# KITTITAS COUNTY

## DEPARTMENT OF PUBLIC WORKS

### MEMORANDUM

TO: All Staff  
FROM: Public Works Planning Review Team  
DATE: September 25, 2020  
SUBJECT: LPF-20-00004 Palomino Division 4

Surveyed by LMH	Scale 1" = 100'
Drawn by Tml/FCS	Sheet 2 of 6
Checked by FCS	Project No. 18146

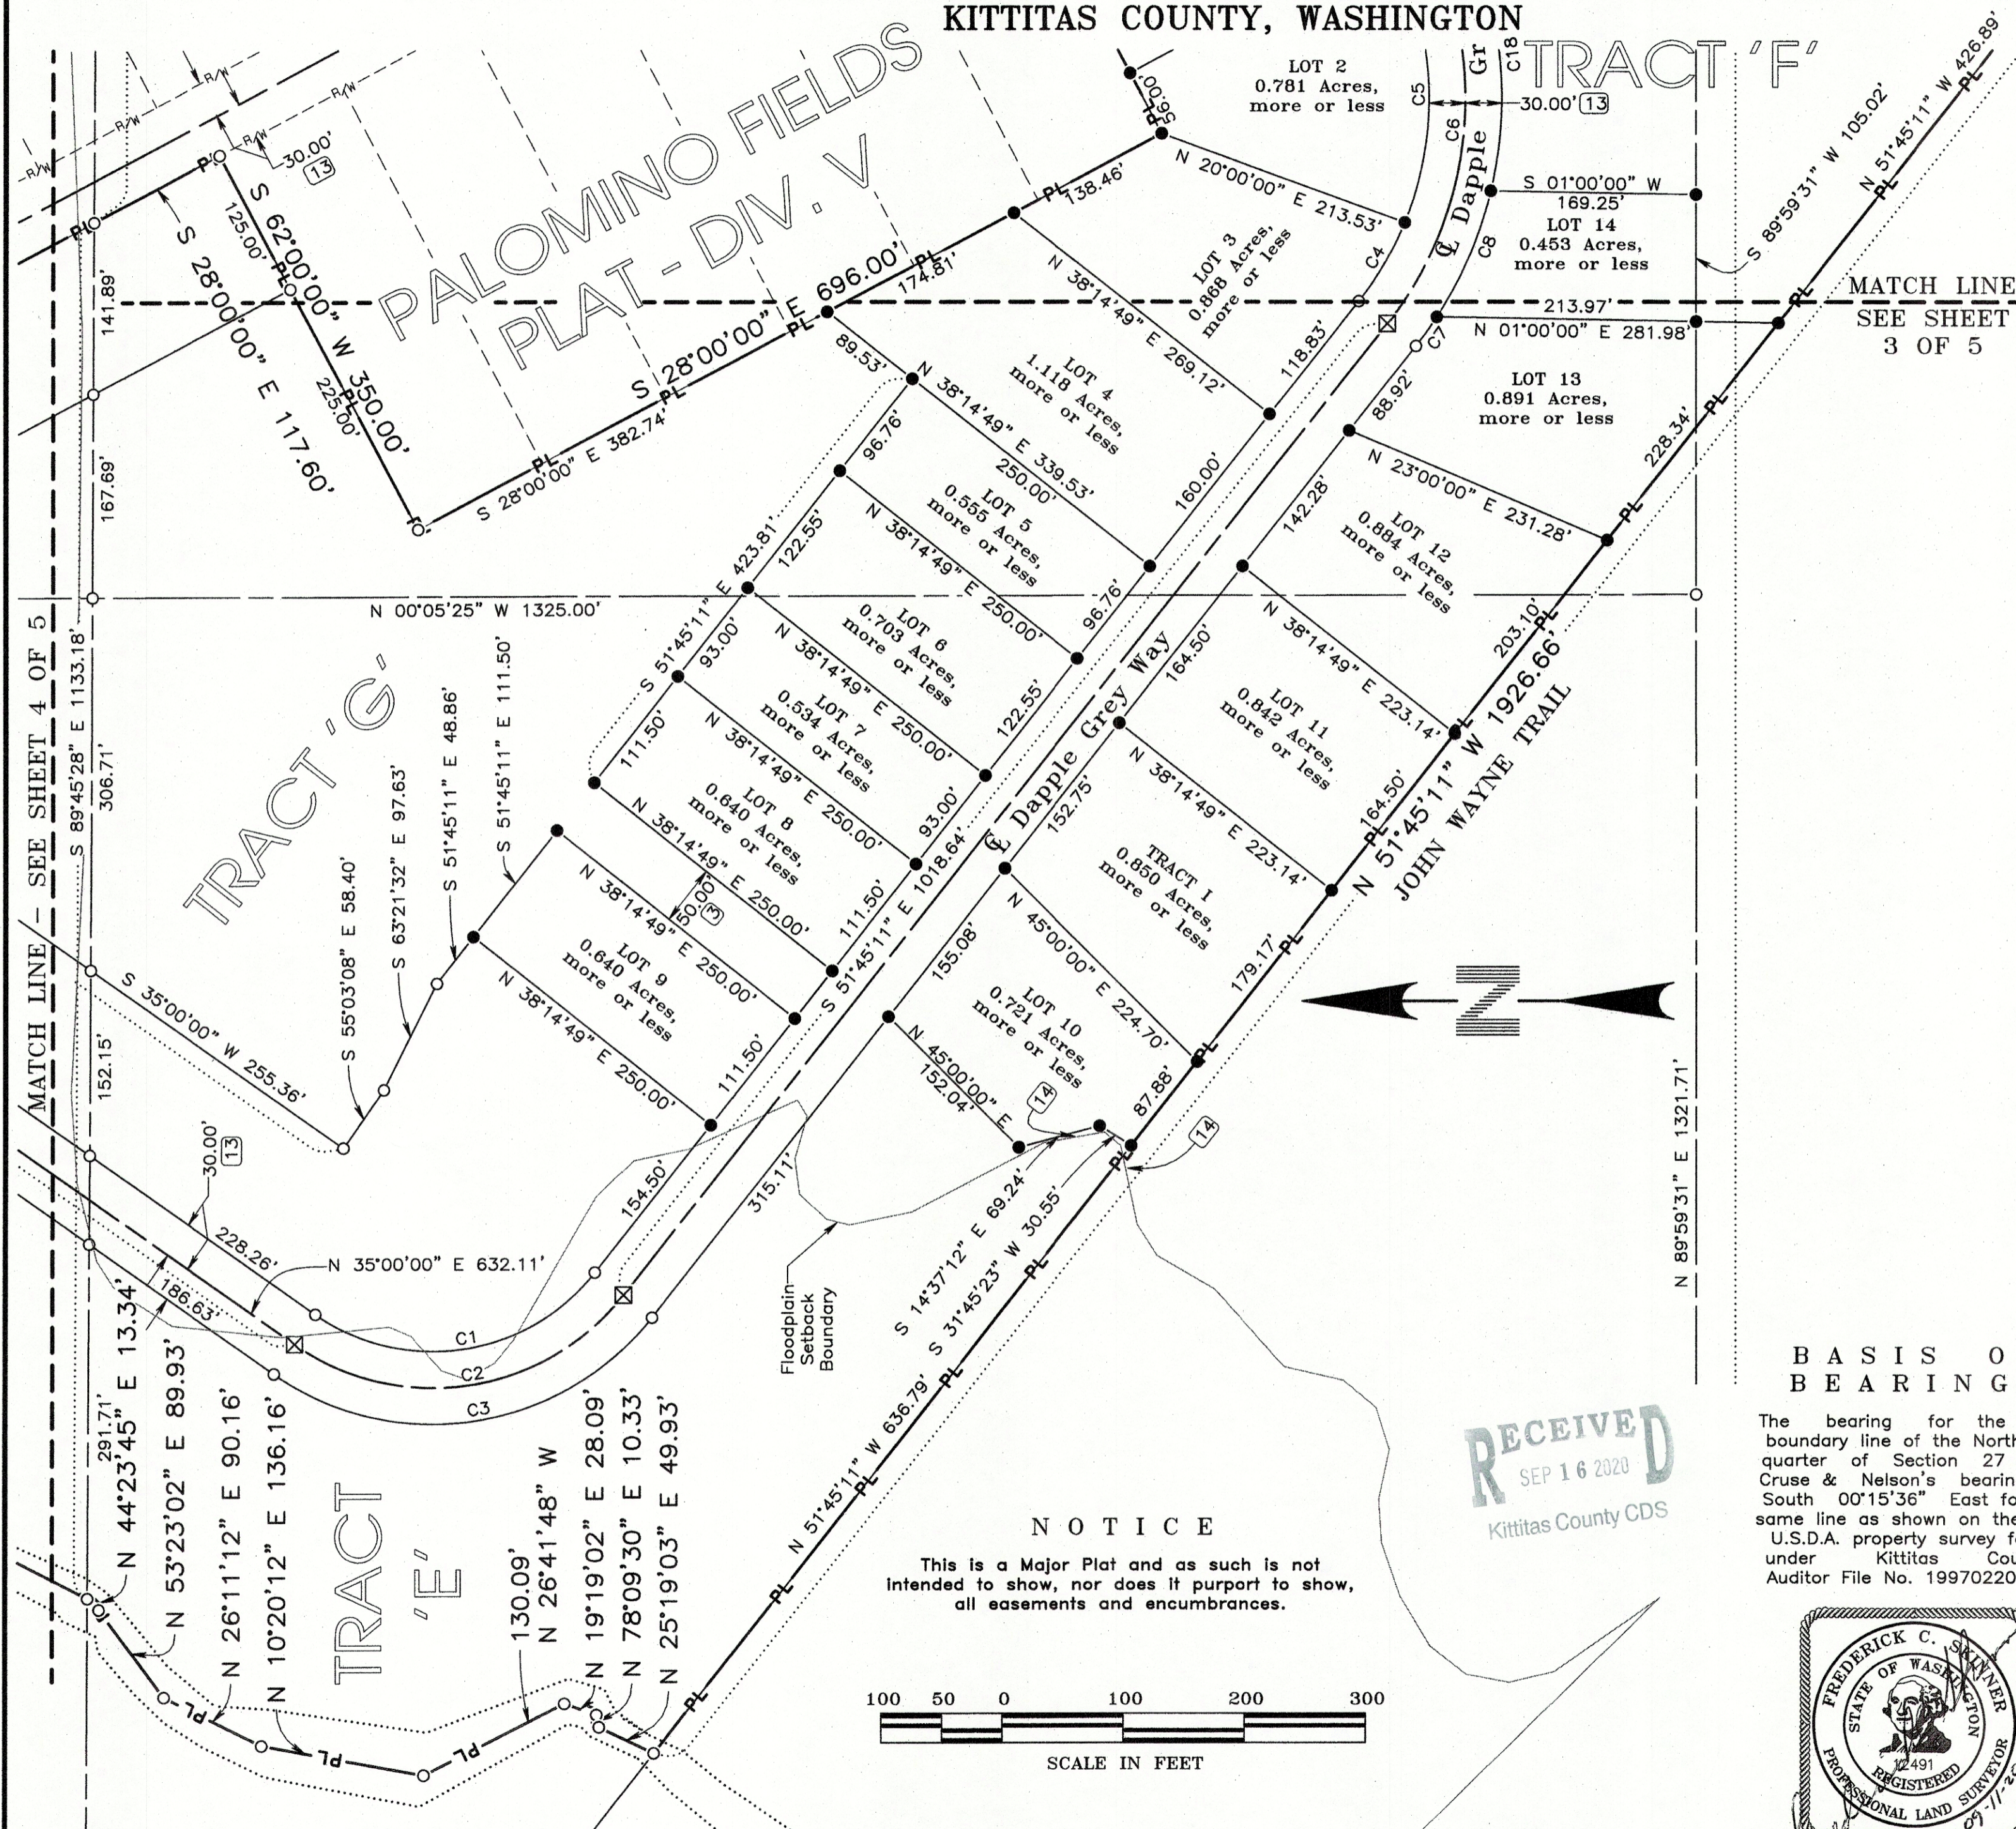
- a. Northernmost line of Tract F, shown as 146.15 feet in length, and appearing on sheet 3
- b. Easternmost line of Tract F, shown as 482.88 feet in length, appearing on sheet 3
- c. Curve on East boundary of Tract H, shown as C17 on sheet 4
- d. Curve of the East boundary of Tract e, shown as C3 on sheet 2

5. Note 13 is shown as reference to existing right of ways. Note 13 calls out “for emergency purposes” and is likely not relevant for primary access roads. This appears on multiple pages
6. Tract ‘H’ should be labeled

LCU, INC.	
Surveyed by LMH	Scale 1" = 100'
Drawn by Tml/FCS	Sheet 3 of 6
Checked by FCS	Project No. 18146

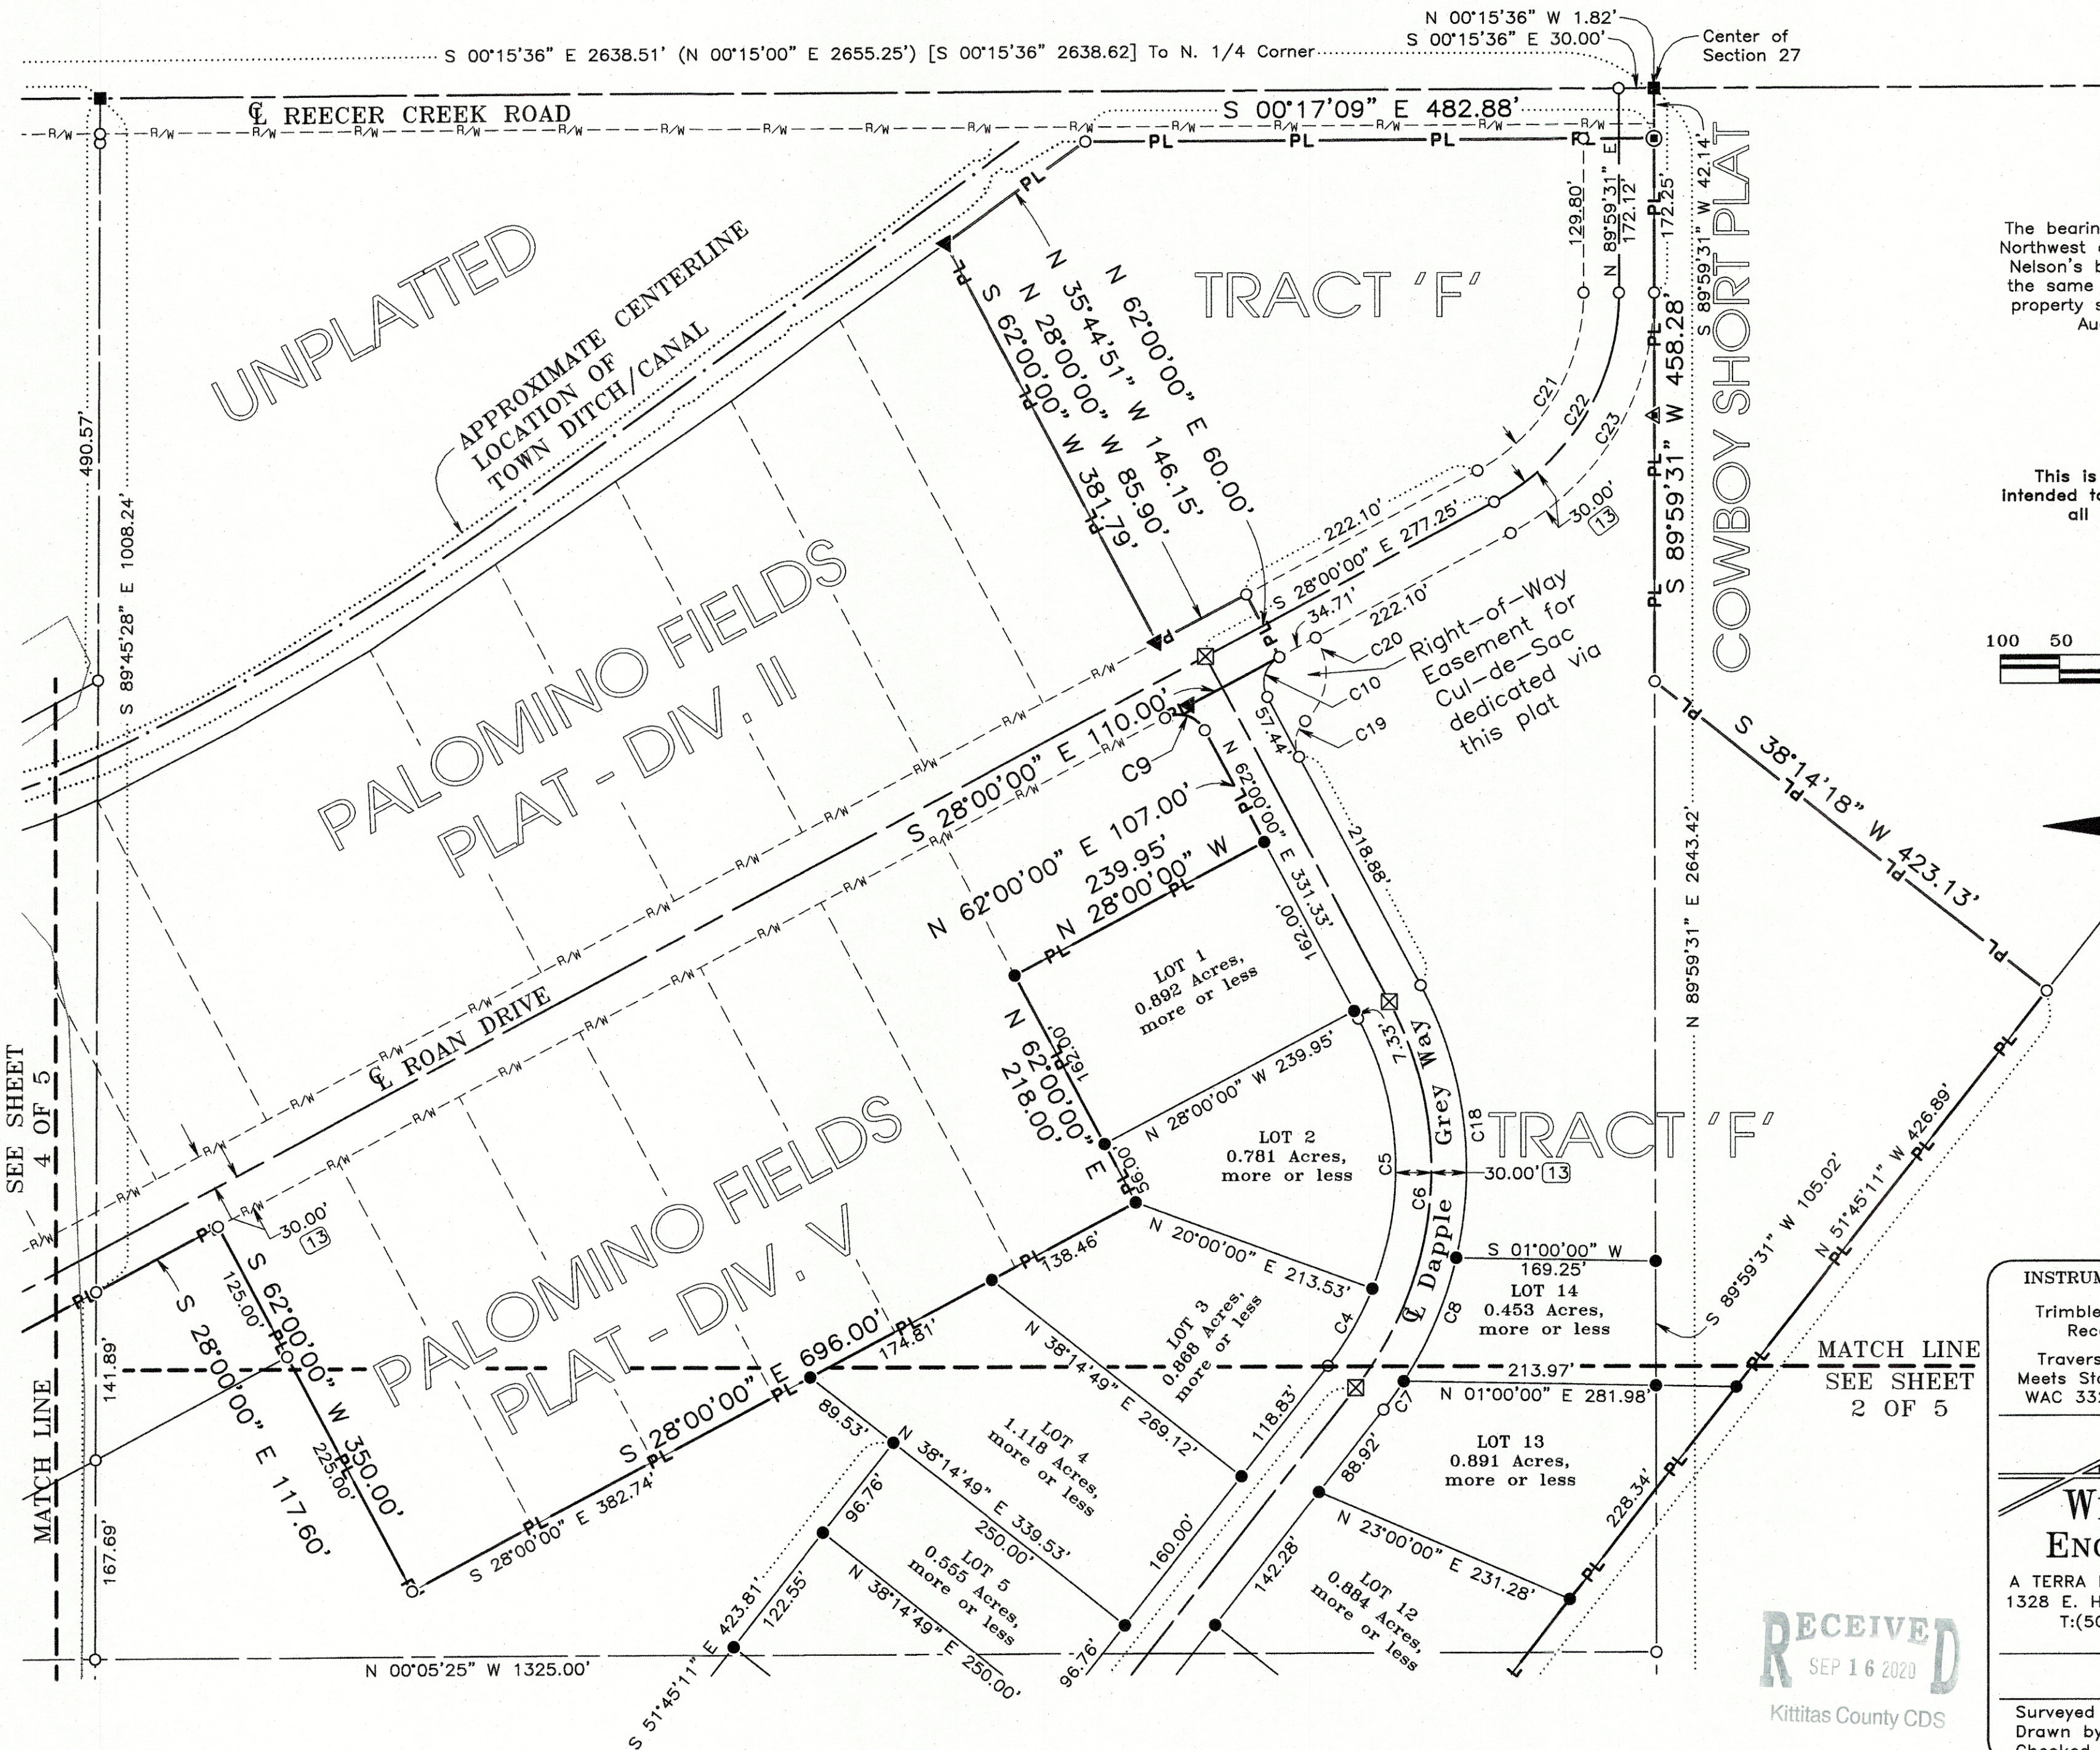
7. There is some confusion regarding the cul-de-sac area. WPE has identified this as a Right-of-Way easement. Please show this as right of way dedicated, and remove the included area from the total area of Tract F. Please also include the portion of the right of way on the East side of Road drive, as shown on Palomino III and V.

A REPLAT OF TRACTS 'B', 'C', AND 'D', PALOMINO FIELDS PLAT - DIVISION IV
A PORTION OF THE S 1/2 OF THE NW 1/4 OF SECTION 27, TOWNSHIP 18 NORTH, RANGE 18 EAST, W.M.
KITTITAS COUNTY, WASHINGTON

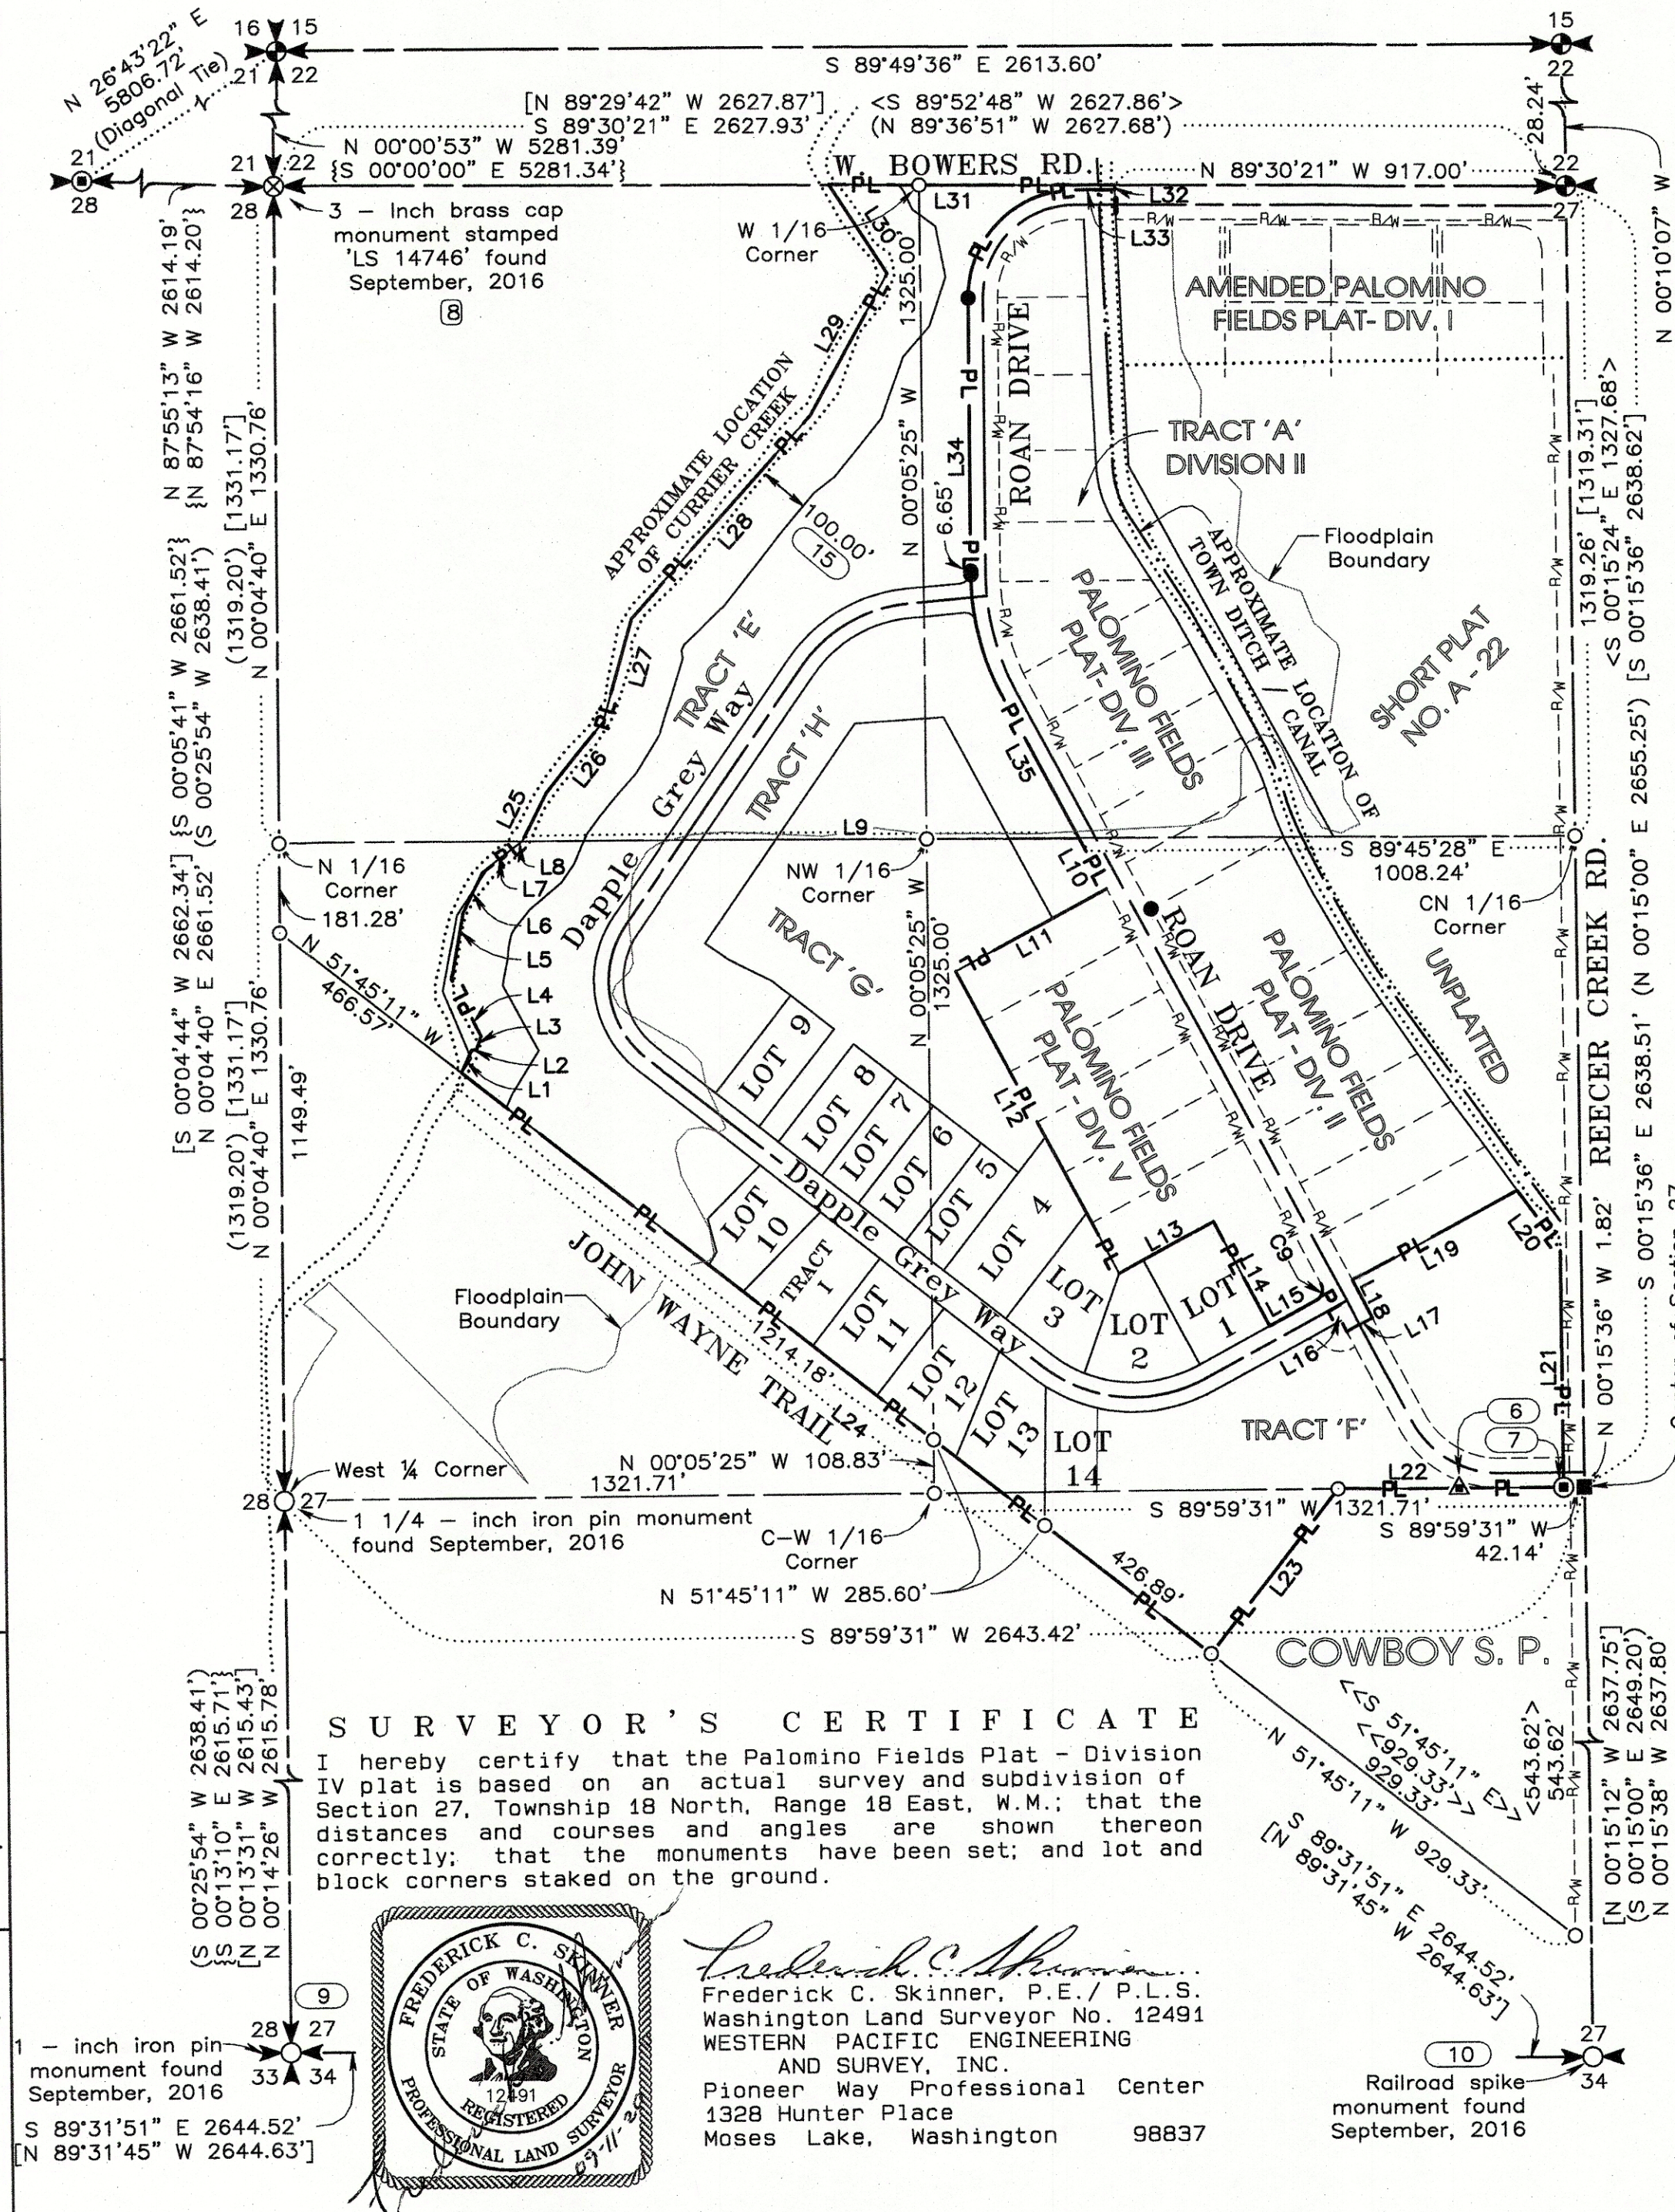
2. There is a dimension North of the intersection of Roan Drive and Dapple Grey Way, being 6.65' in length. This would be better suited to appear on sheet 4.
3. The 100' flood setback is shown as note 15. There is no note 15 of Sheet 5.
4. There is an existing building near Tract I. Please show this building and dimension to boundary lines to ensure it meets setback requirements. Typically, this would be done as part of the preliminary plat, But I have never performed a formal review of a preliminary plat for this project.
